**WELWYN HATFIELD BOROUGH COUNCIL
EXECUTIVE DIRECTOR - PLANNING, PUBLIC PROTECTION AND GOVERNANCE**

DELEGATED APPLICATION

Application No: 6/2021/1380/FULL
Location: 12 Southfield Welwyn Garden City AL7 4ST
Proposal: Change of use to plant hire (retrospective)
Officer: Mr Raymond Lee

Recommendation: Refused

ADDRESS	12 Southfield Little Burrow Welwyn Garden City AL7 4ST
SCALE	1 : 200 /A3
DATE	April 2021
DRAWING NO	SFD/03

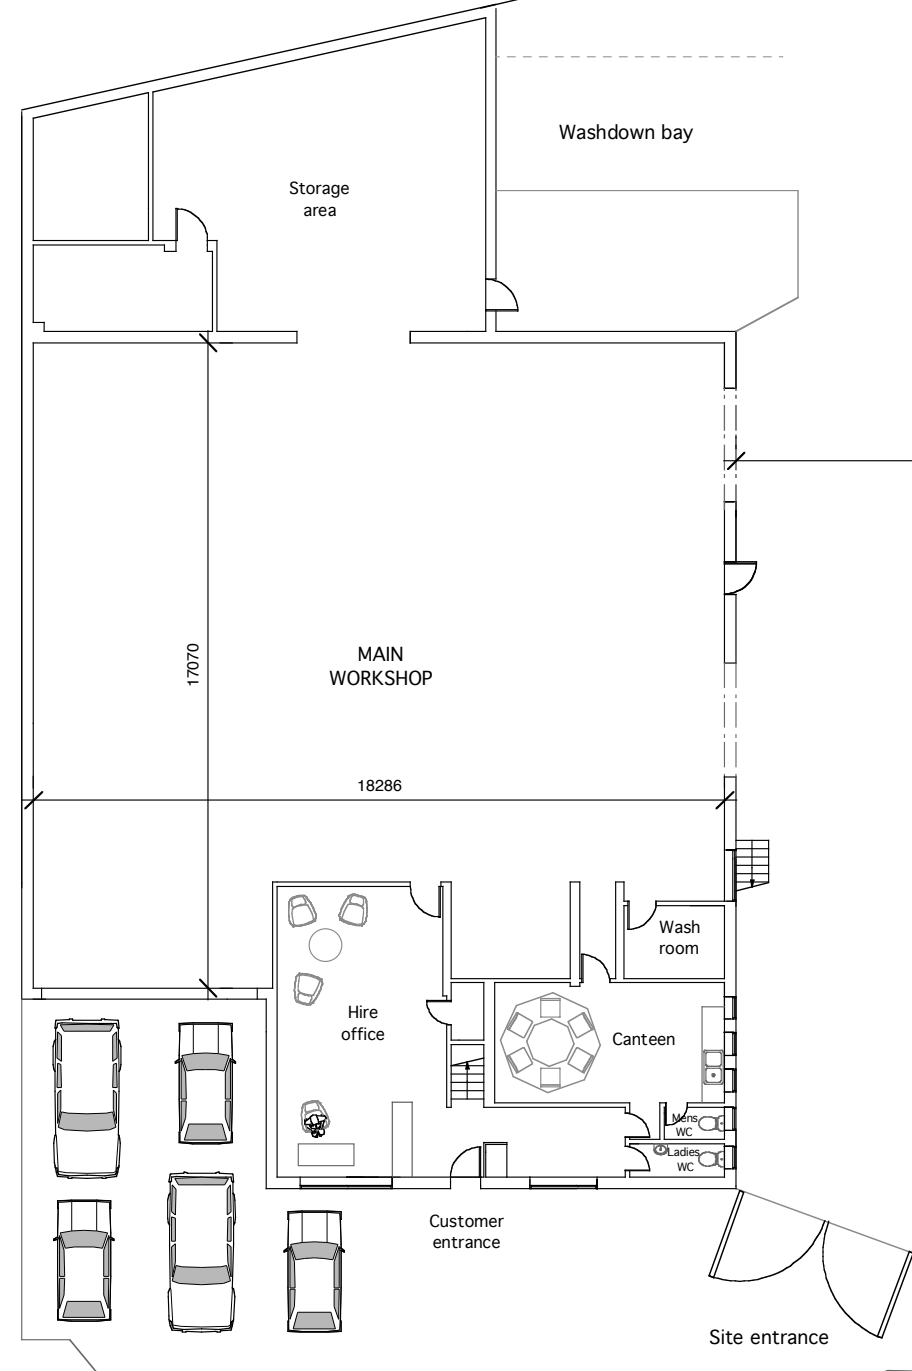
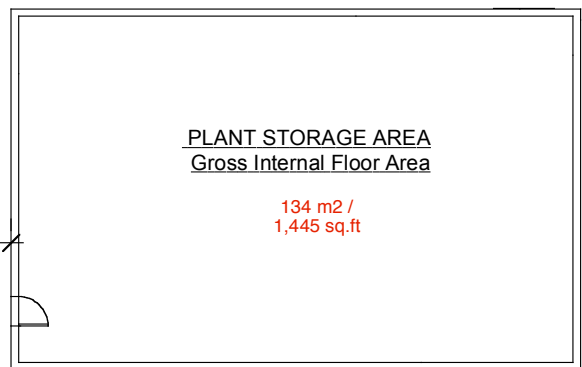
The site lies within parking Zone 4 as set out in the Supplementary Planning Guidance (SPG) Parking Standards. In terms of calculating the parking requirement, the Council's Parking Standards require three parking spaces per four employees in the case of a sui generis hire car use. However, in this case, given the nature of the proposed use where plant and machinery from construction sites are collected, serviced, stored and delivered at the site, it is considered more akin to a mixture of B2 and B8 uses. The applicant agrees with this notion within paragraph 6.5 of the submitted planning statement. On this basis, with the site measuring approximately 677sqm, this would equate to the need to provide a maximum of 9 (B8) - 13 (B2) car parking spaces. The submitted plans suggests that only seven parking spaces are proposed which falls short of the guideline standards. The parking layout is also shown on the plans as being in an informal tandem arrangement and whilst this is not, in and of itself, deemed to be unacceptable, the spaces are shown to fail to meet the minimum dimensions required and the main parking area is situated to the front of the main access door to the workshop. Although the applicant states that the door is inactive, it appears to be the only suitable access for larger plant and equipment. As such officers are not satisfied how practical this proposed parking arrangement will work on the ground. Whilst the maximum parking standards contained within the SPG should normally be taken as guidance only, in this case, given the long standing on street parking issues along Southfield and Burrowfield, any further deficiencies in the parking provision would exacerbate the footway parking issue in the area and result in harm to highway safety. Therefore, in this instance, the proposed parking provision and arrangement is considered to be inadequate for the development proposed. Whilst the County Highways Authority had raised no objections,

<p>they note in their response that the overall determination of parking provision is a matter to be dealt with by the LPA.</p> <p>In terms of access and servicing, the submitted details demonstrate the largest vehicle to be used in association with the business (12mx2.55m 26 tonne rigid truck) can enter/exit in forward gear and sufficiently turn on-site within the yard area. Therefore no objection was raised by the Highways Authority subject to a planning condition requiring that the turning area is retained and kept clear at all times for loading and unloading purposes to prevent conflict with neighbouring areas, pedestrians, cyclists and vehicles. This does not however overcome the issue raised above in relation to the shortfall in parking and its resultant effect on the existing on-street parking pressures in the surrounding area.</p> <p>Part (v) of the policy requires that any retail element of the proposal should be ancillary to the main business use. The proposal does not include any retail element, and as such will not be contrary to this part of the policy.</p> <p>Overall, whilst the proposed sui generis plant hire use would be deemed compatible with the surrounding employment area, the development, by virtue of the under provision of appropriate on-site parking spaces, would exacerbate the already severe on-street parking issues in the area and result in detrimental harm upon Highway safety. On this basis, the proposal would be contrary to Policy EMP2 and M14 of the District Plan.</p>

1. The proposed development, by virtue of the under provision of appropriate onsite parking spaces, would exacerbate the existing on-street parking issues in the area and result in detrimental harm upon highway safety. The proposal would therefore be contrary with the aims and objectives of Policies EMP2 and M14 of the Welwyn Hatfield District 2005 and the relevant guidance in the NPPF.
